Our Ref: 110512-04-Submission Response Letter.docx

**Subject:** Eastern Creek Retail Outlet Centre (ECQ Stage 3); SSD 10457 response to submissions

The Department of Planning, Industry and Environment submission dated 24 February 2021 included Environment, Energy and Science Group (EES) comments on the ECQ Stage 3 Flood Assessment prepared by J. Wyndham Prince in December 2020. The EES submission indicates that the flood assessment is satisfactory, however there were some points raised with regard to flood evacuation which required some further consideration. We respond to each point of the EES submission as follows:

Existing Conditions
PMF Flood Hazard Map

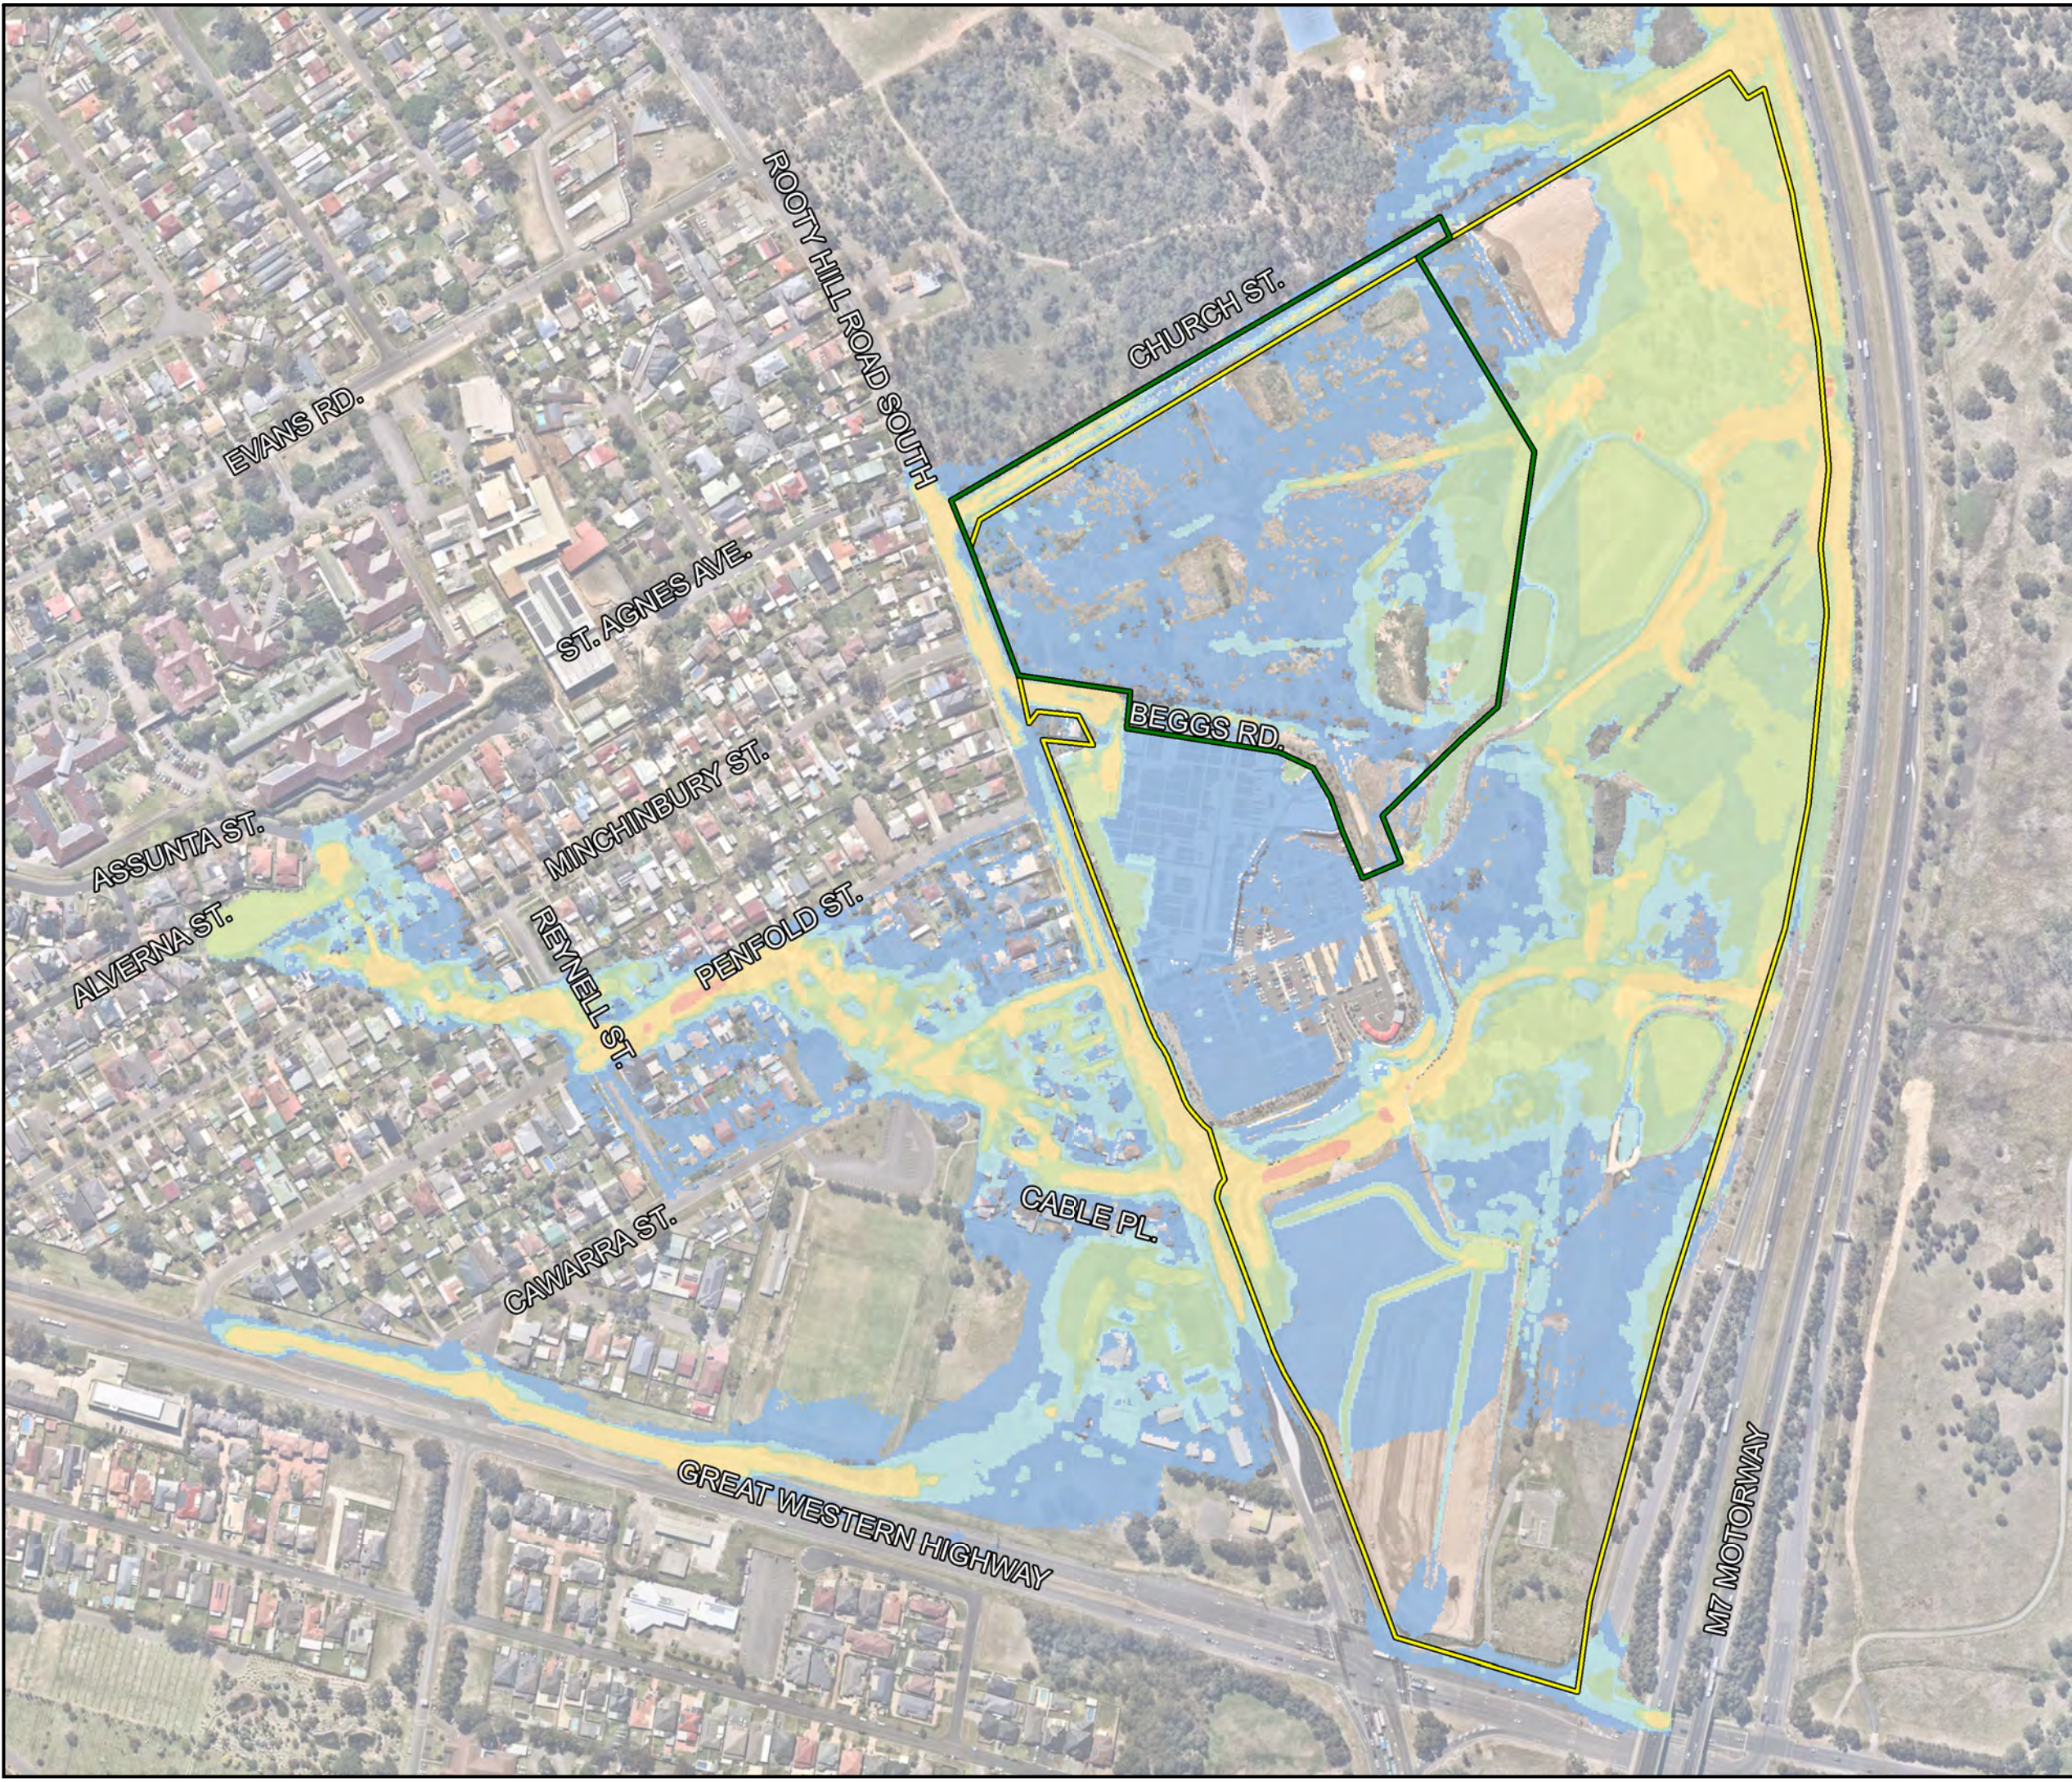
*“The third recommendation states ‘Occupants of Stage 1 and (together with the traversing Stage 3 occupants) are directed to evacuate on foot south along the internal access road and over the internal bridge and through Stage 2 toward the Rooty Hill Road South/Great western Highway intersection’.*

*EES referred to the Eastern Creek Flood Study (CSS, 2014) which shows the Rooty Hill Road South/Great western Highway intersection is cut off by flood water in the PMF event. This hasn’t been shown in Stage 3 Flood Assessment (JWP, December 2020) as the limit of mapping excludes the areas inundated by Eastern Creek south of the Great Western Highway.”*

J. Wyndham Prince response – The ECQ Stage 3 Flood Assessment considered regional 1% AEP tailwater levels in Eastern Creek for the local PMF flood event and associated flood hazard mapping. It should be noted that the likelihood of a regional PMF event occurring at the same time as a rare local PMF event is extremely low. The Eastern Creek Flood study (CSS, 2014) indicated that the regional PMF flood hazard at the GWH/RHRS south intersection would be low hazard (see Plate 1 below), and therefore an appropriate pedestrian evacuation could be implemented. Furthermore, we have reviewed Blacktown City Council’s current online flood mapping of the area and it does not indicate PMF flood affectation of the GWH/RHRS intersection. Please see Plate 2 below.
